From: Andrew Robley
Sent: 03 February 2017 15:04
To: Mark Peacock <m.peacock@welhat.gov.uk>
Subject: Northaw, The Oshwal Centre, Coopers lane Road; 16/1067/FUL

EXISTING AND PROPOSED FRONTS
AND SECTIONS

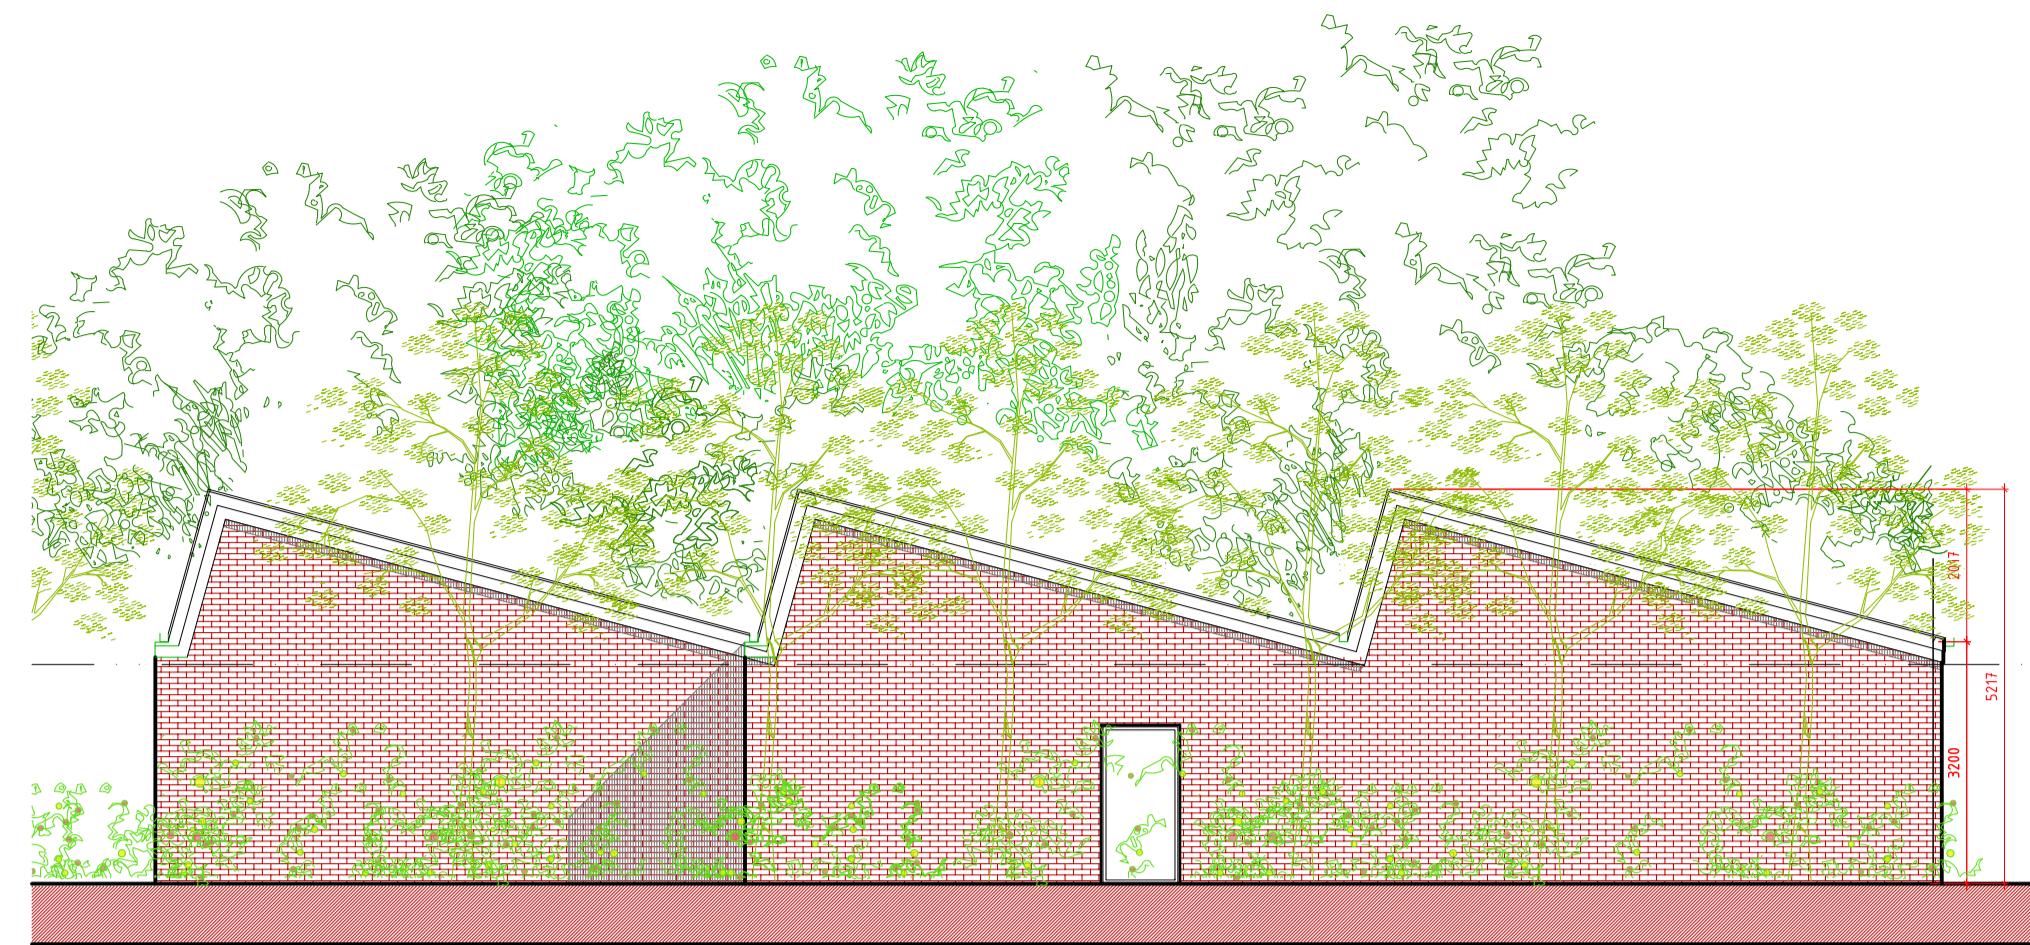
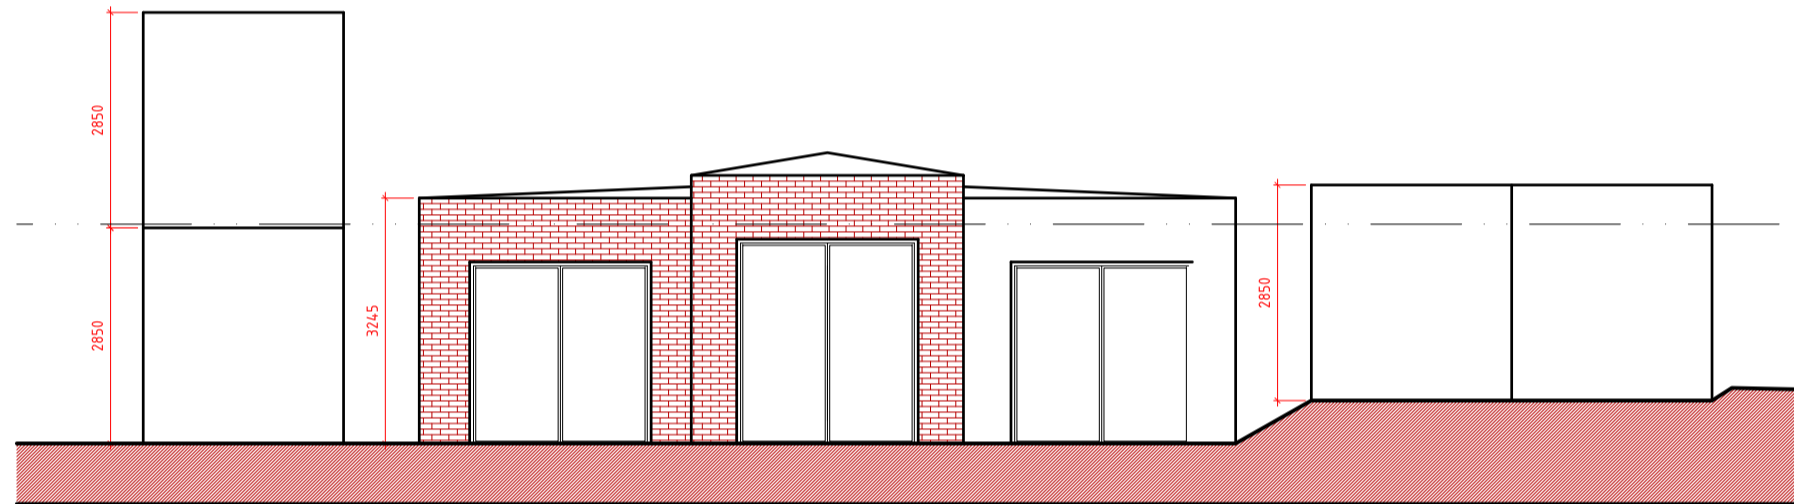
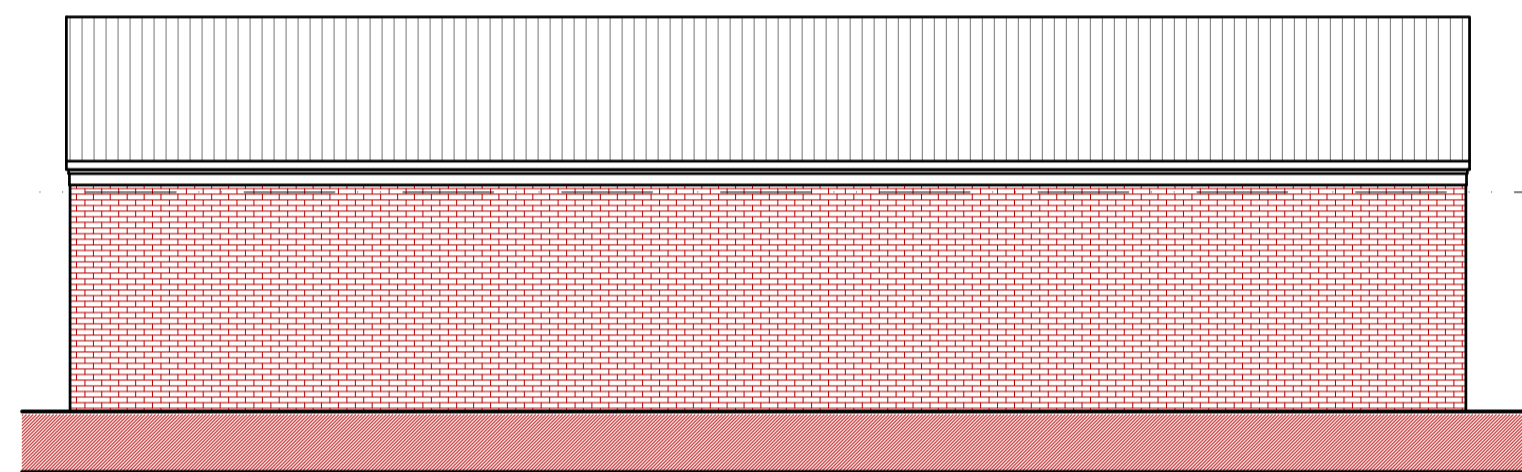
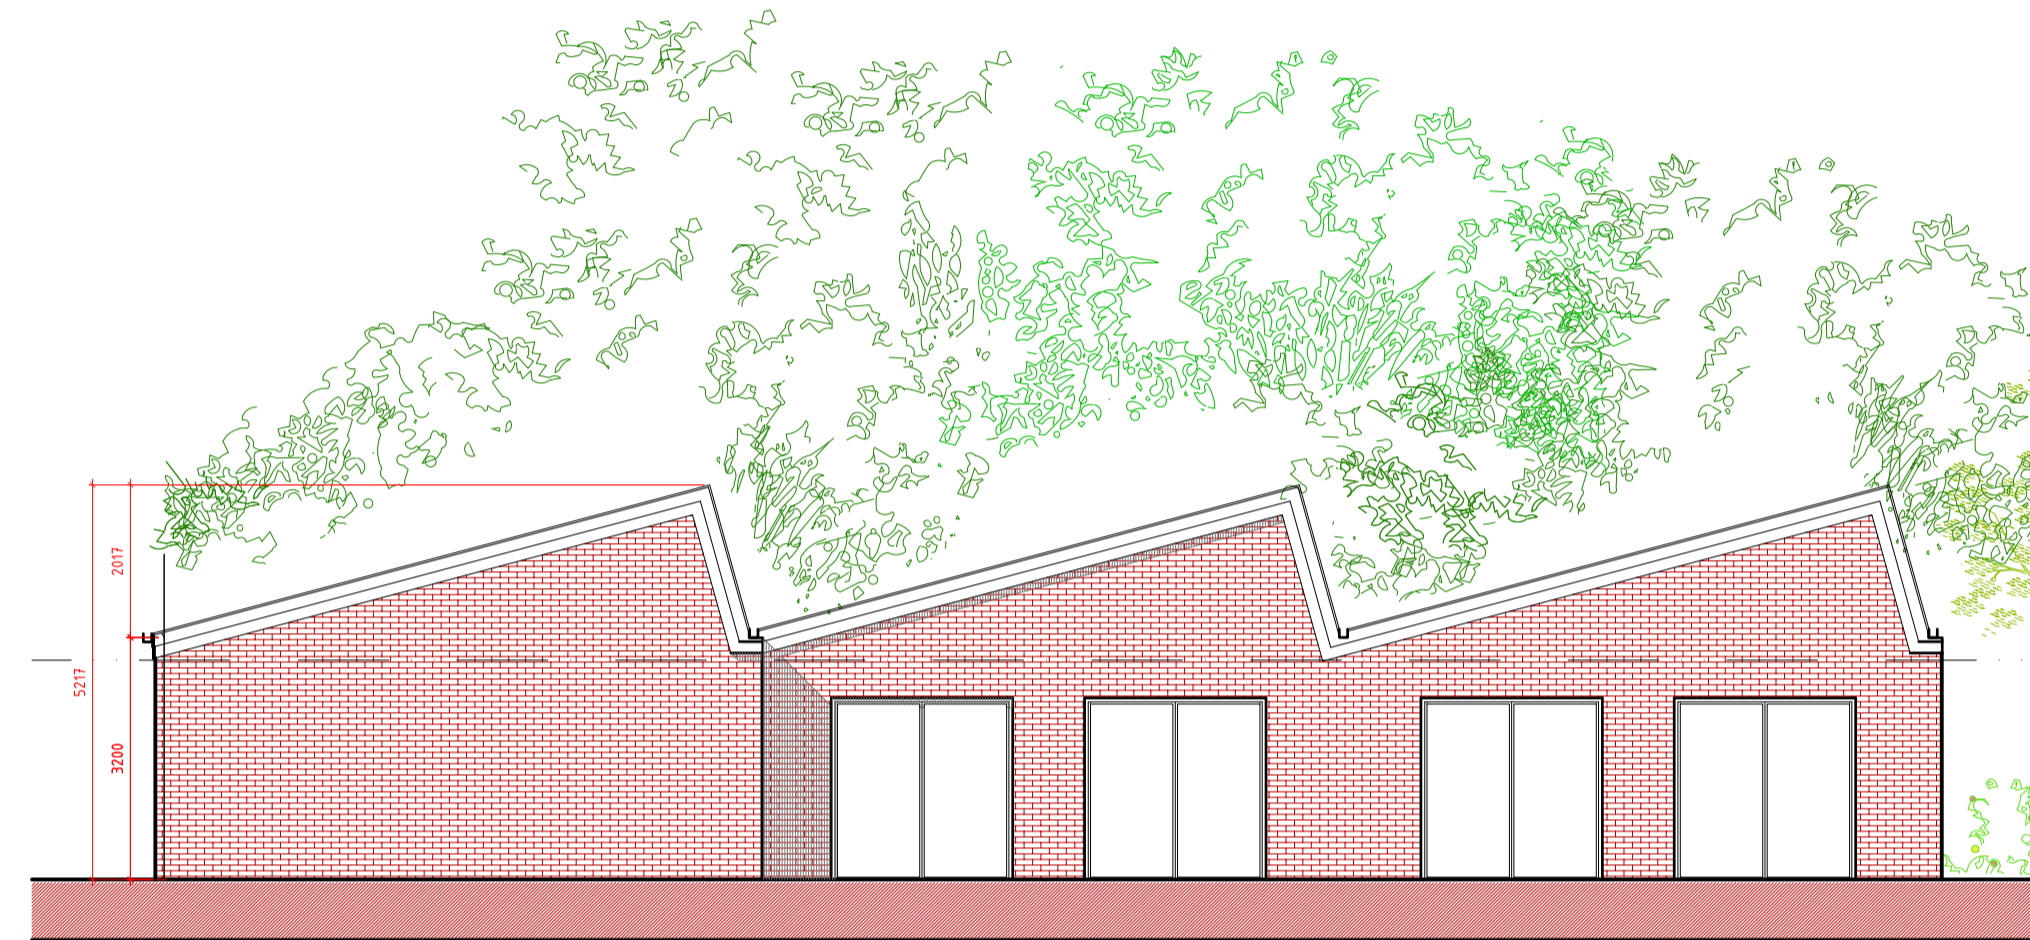
The proposal is to replace this facility with a somewhat larger building and higher in respect of overall roof height which would be approximately 5M. This is because the roof is similar to a C20th factory building in “saw tooth” form with “north lights”. According to the Planning Statement, this is to give extra height for storage and to provide natural day-lighting without low level windows (for security).

Whilst the current shipping containers should not set a precedent for the amount of building, in my view a building of this area and in this location would in principle not necessarily, significantly harm the setting of the listed building, However, the overall amount of building in this corner is becoming an issue and therefore it should be made as inconspicuous as possible. The additional height is therefore an issue and the “saw tooth” roof draws attention to this.

Whilst the building is set down into the landscape, it would be advantageous for the banking up of a grassed bund , which could also be planted with screening planting. In addition, the Architects should consider turning the roof form by 90 degrees so that the saw tooth form is facing away from the LB. it would also be advantageous to consider a “green roof” which would also blend the building into the landscape and avoid the appearance of standard profiled metal roofing which might otherwise be contemplated.

The amendments have resulted in a roof which is re-oriented and “greened” as recommended. It doesn’t appear to have been reduced in height but nevertheless would be of less visual impact from the listed house. This would be helped by introducing a landscape bund and screening planting.
